**Attachment A – Detailed response to all submissions**

Green Square Integrated Facility and School – State Significant Development Application

DA-B10-00-00

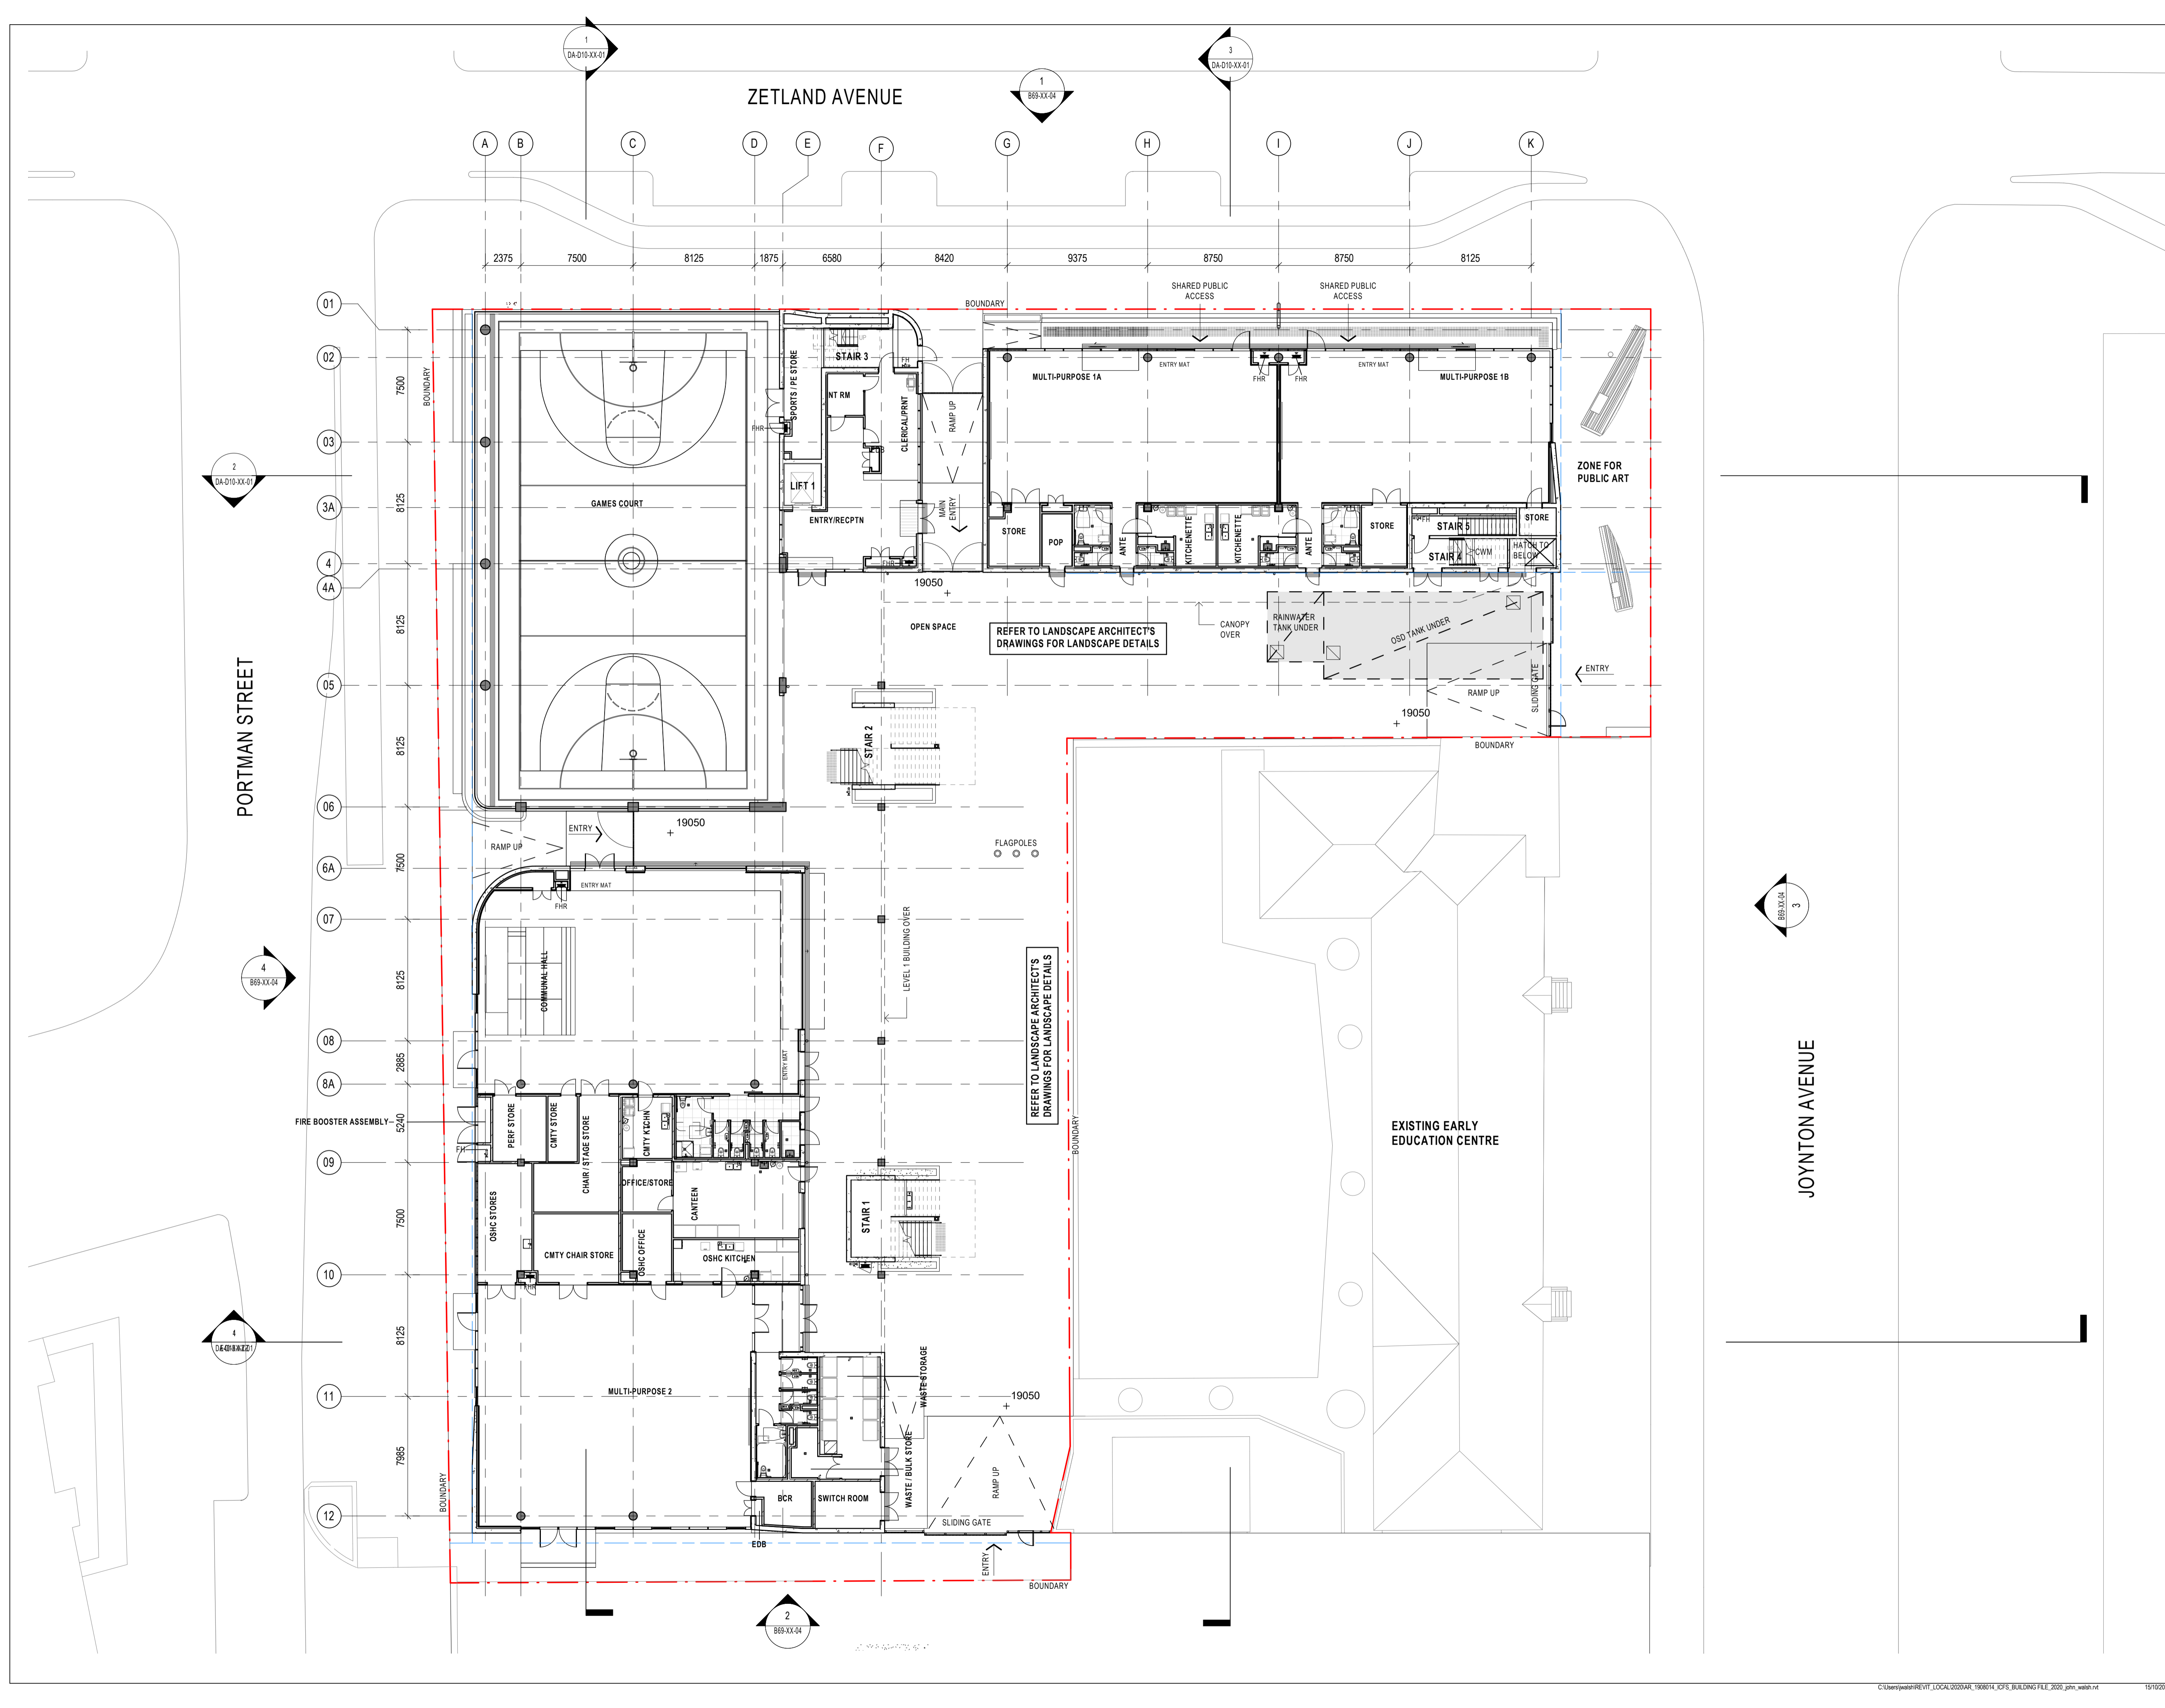
<p><u>Access</u></p> <p>12. <i>The recommendations of the Access report should be incorporated into the plans including:</i></p>	<p>12. The recommendations of the Access Report have been incorporated into the plan as follows:</p> <p>a. Plans updated to incorporate north ground tactiles. Refer to drawing number: DA-B10-00-00. For detail setout refer to drawing number DA-F63-XX-01.</p>

Issue	Response
<p>a. <i>North Ground Level – Require tactile indicators are to be shown to the bottom of stairs and dimensions provided of the projections into the public domain for both tactile indicators and handrail;</i></p> <p>b. <i>accessible car park south ground level – This car space is to be shown on the architectural drawings with the required circulation space to ensure this can be accommodated in the design.</i></p> <p>c. <i>general – the other internal planning design changes recommended in the access report are to be incorporated into the architectural plans.</i></p>	<p>b. There is no accessible parking or general parking proposed on the site. Detail of accessible car park has been removed from the Access Report which was included erroneously. Refer to updated Access Report at <b>Attachment D</b>.</p> <p>c. Recommendations have been captured in the drawing set. These changes have been clouded for ease of reference.</p>

Issue	Response
	<p>d. Refer to Bike Parking locations illustrated on DA-B10-00-00. Refer to landscape report for further detail.</p>
<p><u>Landscape and Tree Management</u></p> <p>7. <i>The proposal does not comply with the City's canopy cover target of 15% canopy cover within 10 years from the completion of development as outlined at section 3.5.2 of Sydney Development Control Plan 2012 (SDCP 2012) and as promoted by the NSW Government's 'Greener Public Spaces'. While it is noted that the site is constrained, the landscape design is to be amended to provide additional capacity for canopy trees to meet this important environmental performance target. The amended design should:</i></p> <ul style="list-style-type: none"> <li>a. <i>achieve the minimum 15% canopy coverage of the site within 10 years from completion of development;</i></li> <li>b. <i>allow for the planting of larger canopy trees rather than lots of small sparse canopy / crown trees to provide meaningful canopy coverage by larger trees;</i></li> <li>c. <i>provide adequate soil volumes to ensure that the new trees achieve their full genetic potential and provide</i></li> </ul>	<p>7. Further information/justification is provided to address the Council's advice as follows:</p> <ul style="list-style-type: none"> <li>a. Sydney DCP 2012 does not apply to the site. Furthermore, in accordance with clause 11 of the SRD SEPP, Development Control Plans (DCPs) do not apply to State Significant Development. Although the Draft Greener Places Guide indicates an overall target of 15% for the CBD, noting that the proposal has been designed within building envelopes established by the design competition jury, the target of 15% cannot be achieved without substantial canopy on the rooftop. However, the use of canopy trees on the rooftop cannot be considered due to safety concerns in high winds. Additional structures would also be required to support deep soil profiles. In effect, additional canopy compromises the ability of the rooftop to provide Photovoltaic panels and student play spaces. It should be noted that the design provides a net gain improvement increasing the canopy coverage from 5.5% to 8.4% within 10 years from the completion of development. This is an increase of 161m<sup>2</sup>. The proposed canopy cover is considered to be an appropriate response in the circumstances.</li> <li>b. It should be noted that the design has been worked through in consultation with the City of Sydney Design team. Larger trees have been located in open areas to maximise canopy coverage and amenity in key locations, with smaller trees located closer to the boundary of the childcare to prevent overshadowing and leaves falling into the childcare centre. It is considered that the proposed development has already maximized the amount of larger canopy trees that can be accommodated at the site. Notwithstanding this, the landscape consultant has identified alternative tree species for the consideration of CoS. Refer to Page 18 of <b>Attachment H</b> for list of tree species.</li> <li>c. The landscape architect has advised that adequate soil volumes have been provided. A majority of the trees are to be located in deep soil.</li> <li>d. Newly planted trees will meet this Australian Standard.</li> </ul>

AR-DA-B10-04-00

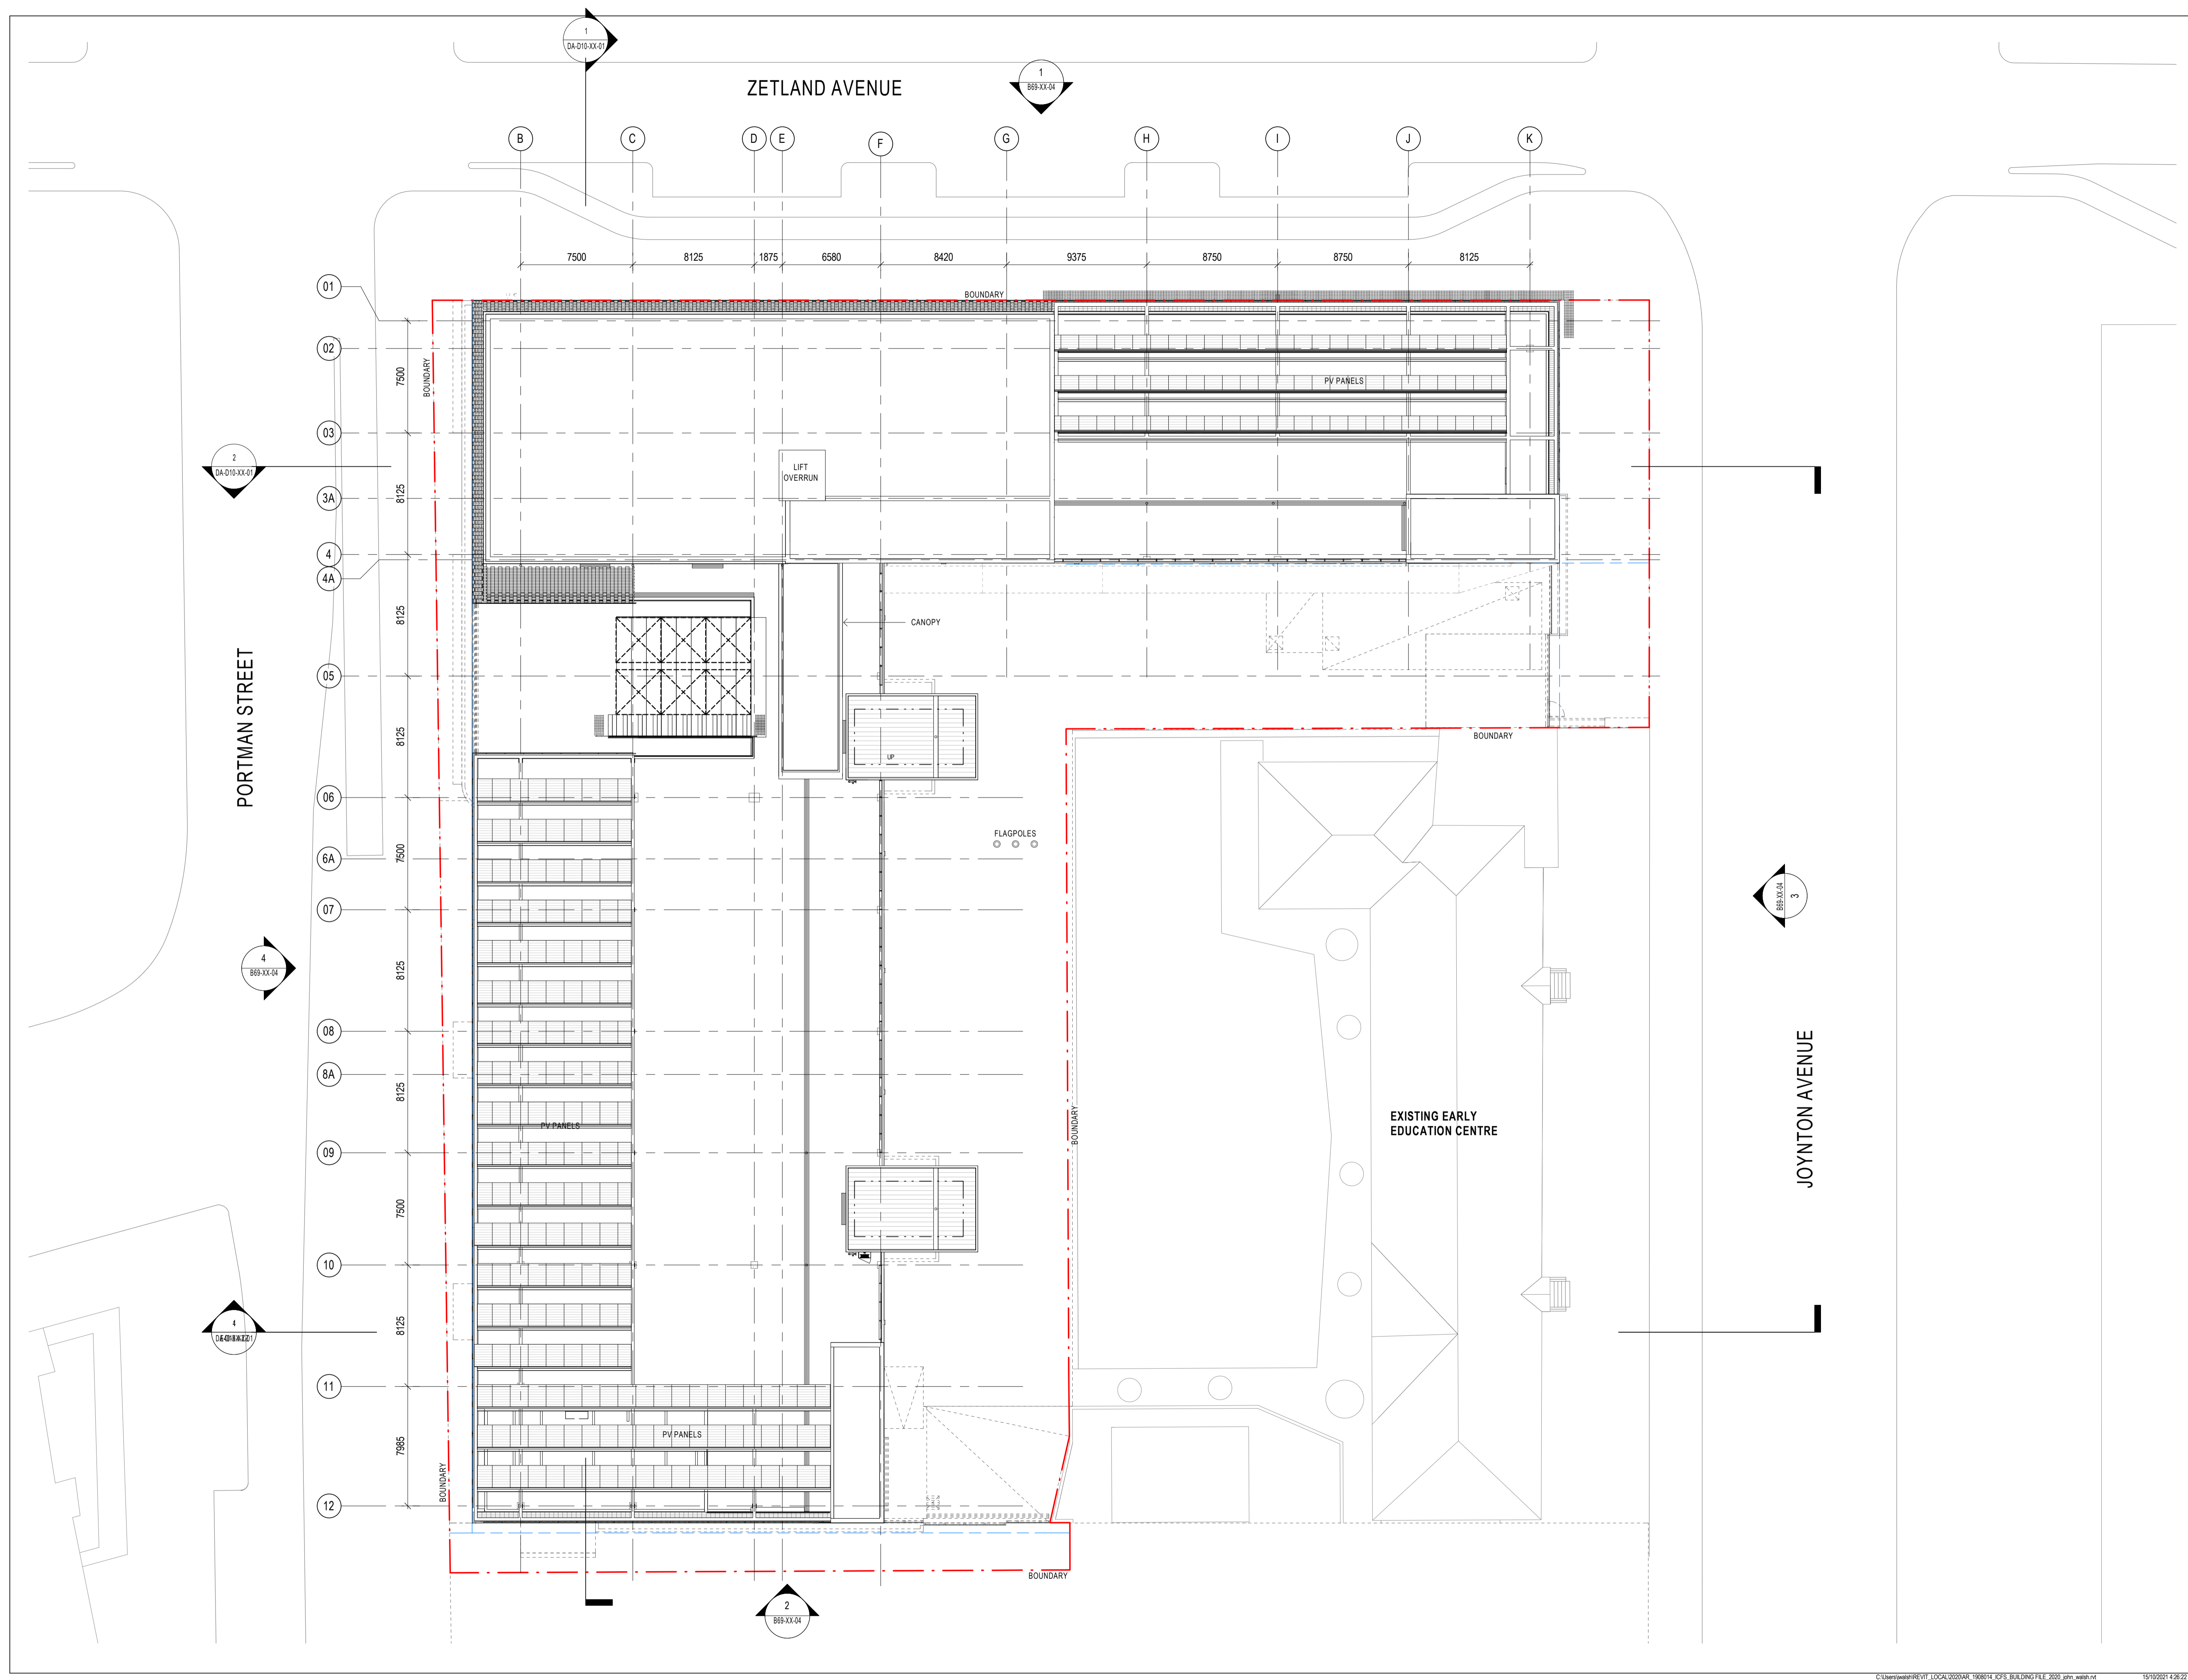
<p><u>Design Advisory Panel (DAP) Comments</u></p> <p>10. <i>An update to the Architectural Design Report or amended plans is to be provided which formally addresses the DAP comments as follows:</i></p> <ul style="list-style-type: none"> <li>a. <i>façade Proportions of Concrete Spandrel &amp; Flexbrick Screening Relationship – Further analysis and reasoning for these changes from the Design Excellence</i></li> </ul>	<p>10. Further information/justification is provided to address the Council's advice as follows:</p> <ul style="list-style-type: none"> <li>a. further analysis and reasoning of the façade proportions of concrete spandrel and Flexbrick screening relationship has been provided on pages 89 and 90 of <b>Attachment C</b>.</li> <li>b. Internal rendered perspectives have been provided on Pages 91 to 94 of <b>Attachment C</b>.</li> <li>c. Further detail of the roof structure and PV has been provided on Architectural Plans (Ref Drawing AR-DA-B10-04-00 and DA-G40-XX-01).</li> </ul>
